From: Mark Warwick <Mark.Warwick@arun.gov.uk>
Sent: 22 July 2020 17:36
To: 'David Fuller' [REDACTED]
Cc: Zac Denton <Zac.Denton@arun.gov.uk>; Juan Baeza <Juan.Baeza@arun.gov.uk>
Subject: R/62/20/HH

Planning Officer: Mr Z Denton
Planning Application Ref: R/62/20/HH
Location: Smugglers, 4 Botany Close, Rustington, BN16 2BH
Description of works: Erection of detached garage
Comments on Application:

Drawing Name
Plans, Elevations, Roof Plan and Block Plan
Garage -
Proposed

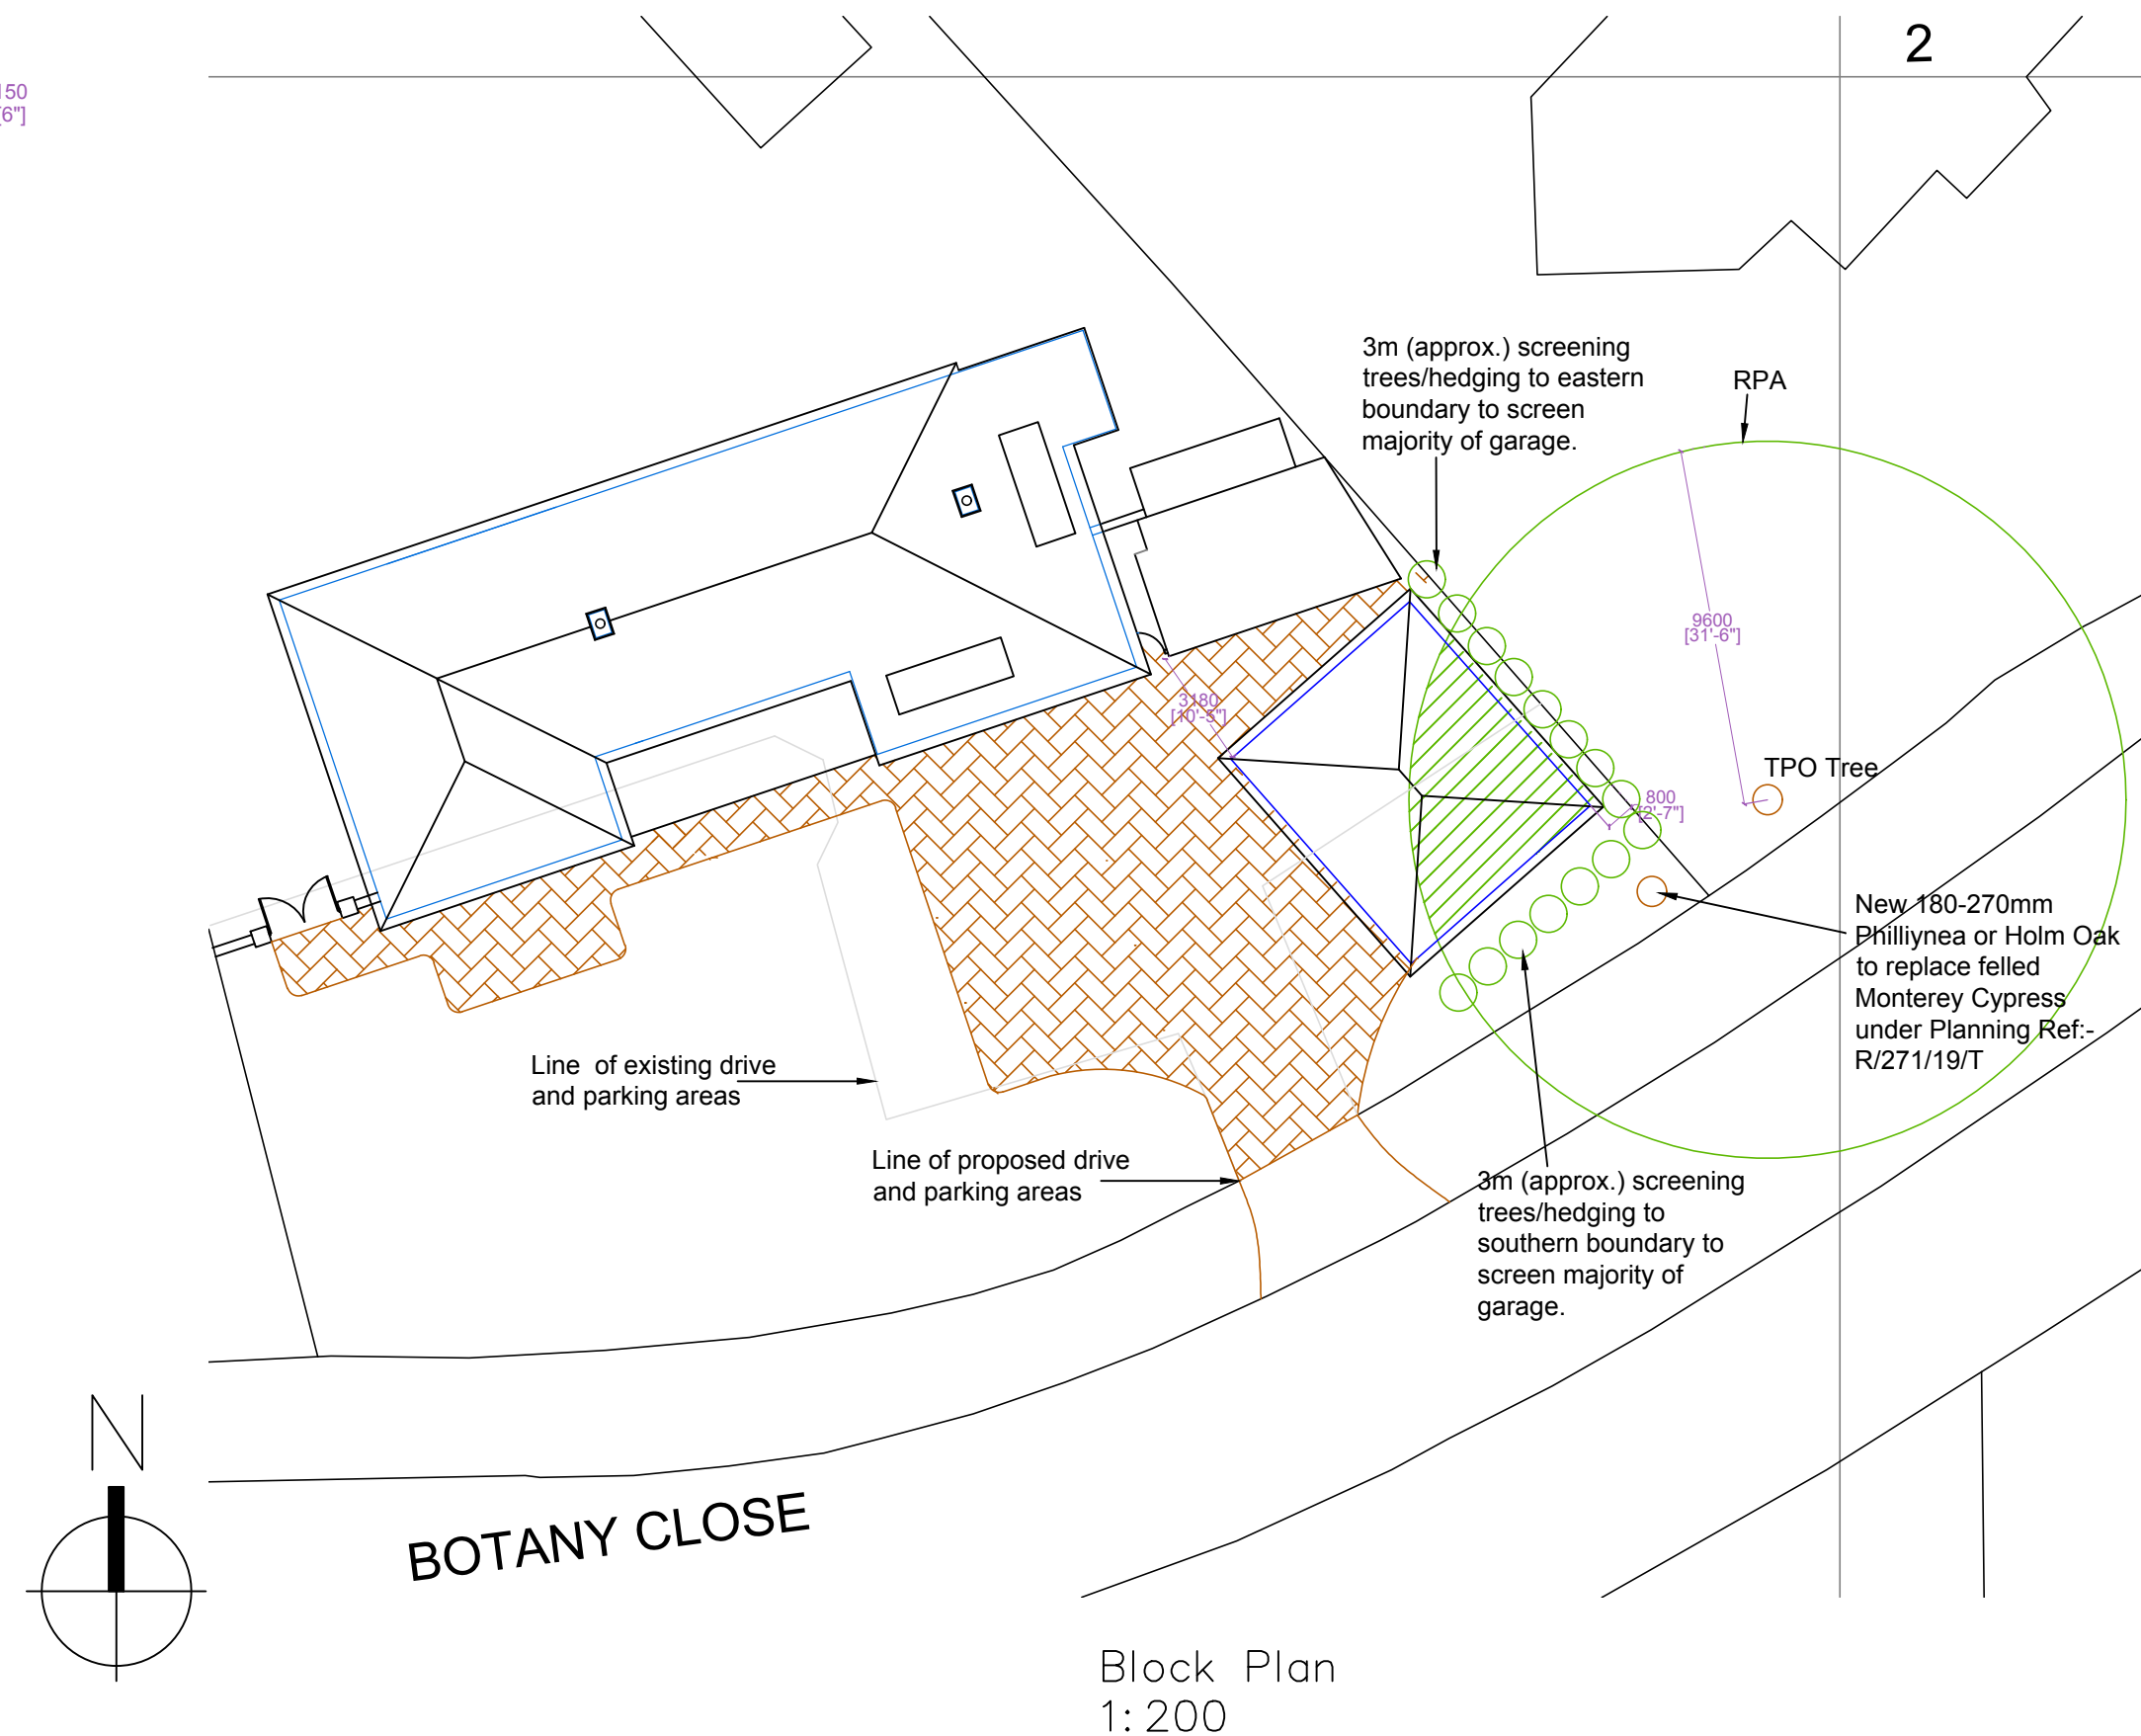
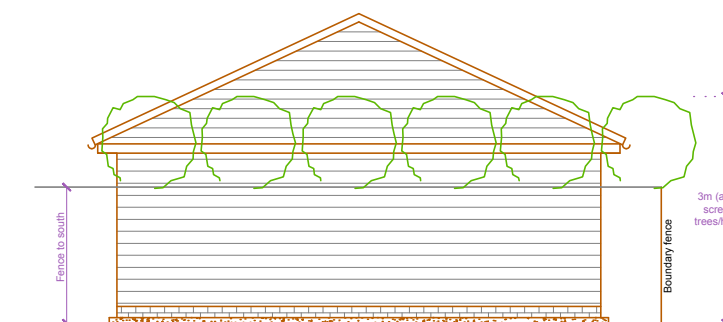
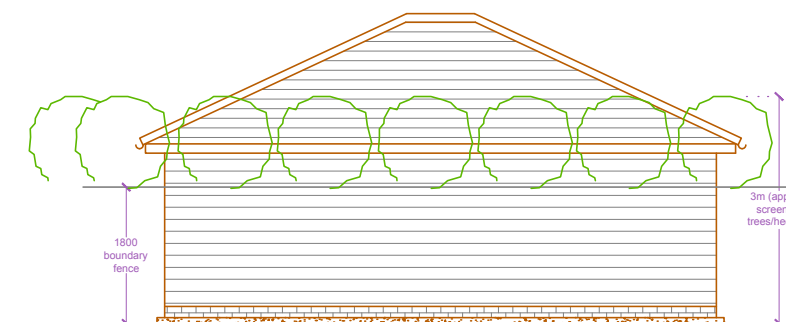
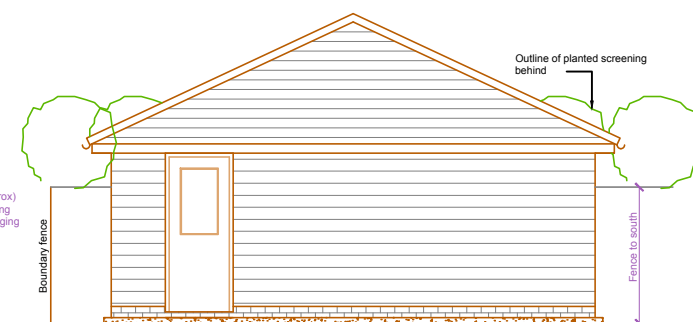
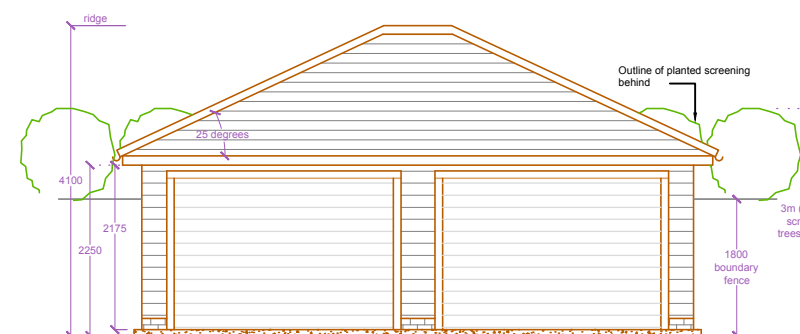
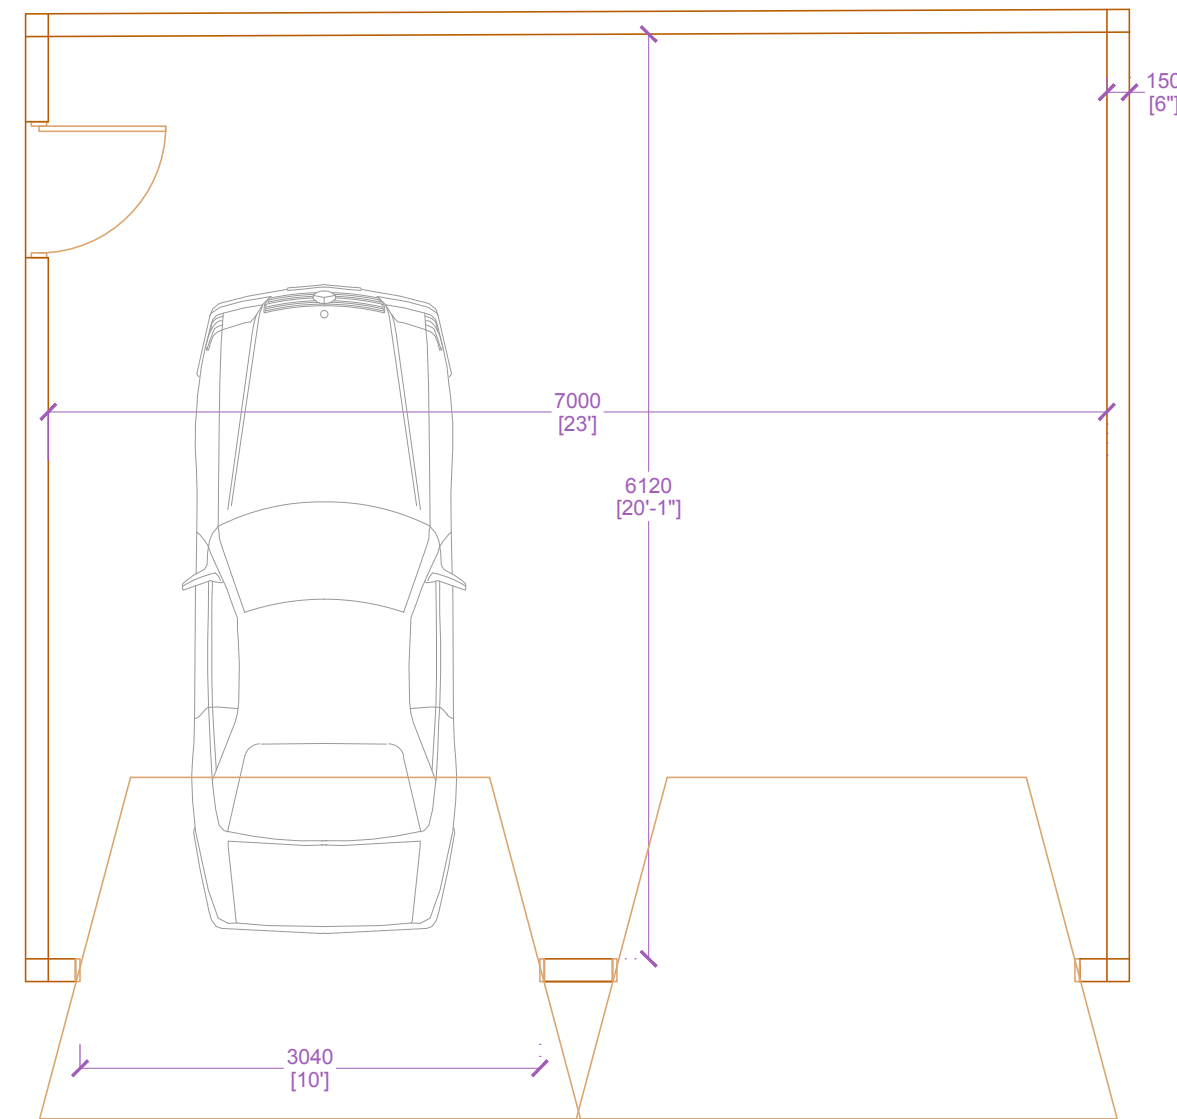
- Notable but tolerable incursion into that tree's Root Protection Area (RPA) is proposed. As such, BS5837:2012 recommends we have an Arboricultural Method Statement (AMS) and also most importantly a Tree Protection Plan (TPP) – to both describe and illustrate the mitigation measures which are to be employed. A briefing note cannot satisfy that requirement.

- The following items will need to be addressed in detail within the above AMS and TPP:
 - RPA overlapping site and beyond footprint of proposed structure to be fenced off to prevent access, storage of materials, contamination risk/compaction.

- Method of excavation and treatment of exposed roots within excavation. Watching brief may be necessary, especially if structurally important roots are uncovered.

- Membrane to prevent curing concrete coming into direct contact with exposed/cut root material.
 - Soft landscape proposals - duty to replant with specimen tree as per R/271/19/T, within RPA. How will the garage structure tolerate a tree of high growth potential in such proximity? Should an alternative front garden location be considered for feature tree planting (*Phyllirea latifolia* or *Quercus ilex*)? Please confirm.
